## Consultees for application 21/04166/F

Planning Application: 21/04166/F

Proposal: Permission is sought to re-position and amend the structure of the previously allowed 3 bedroom building

Location: The Pheasant Pluckers Inn, Burdrop, OX15 5RQ

**PAPER SIZE : A4
SCALE 1: 100
REVISED ELEVATIONS**

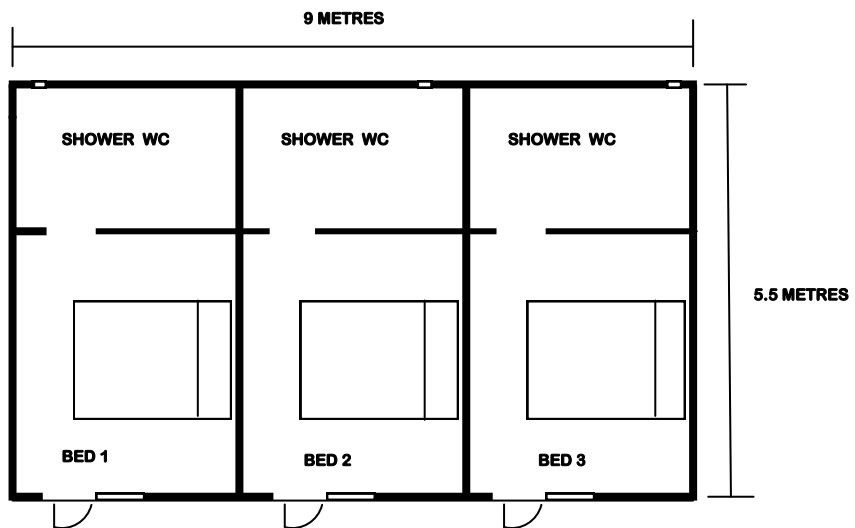
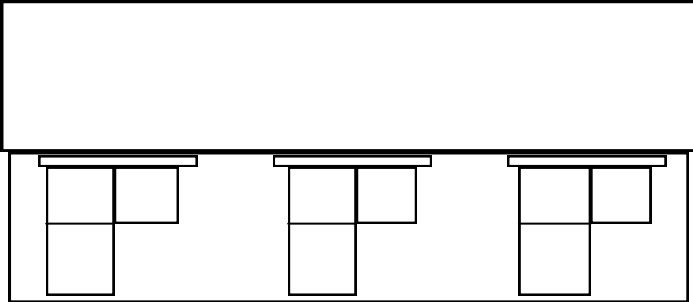
**Size and Scale** – the proposed building has a significantly larger footprint and height, comprising 3 bedrooms, together with kitchen, utility & boots, bathroom and sitting room. This would appear to constitute an entirely new building, identified by the applicant as *the Proposed Cottage*" (p4), rather than an Amendment (p5).

**Design** – the proposed design does not appropriately reflect the photographic evidence provided to support the relocation and is not complementary to this location, thereby having a negative impact on the identified street scene in this sensitive conservation area

**Materials** – the photographic evidence clearly identifies local stone and thatch, which has been retained for the existing neighbouring barn. A similar use of materials would complement the adjacent Grade 2 listed building, generating a positive impact on the street scene in this sensitive conservation area. No specific details are included for doors, windows, rainwater goods
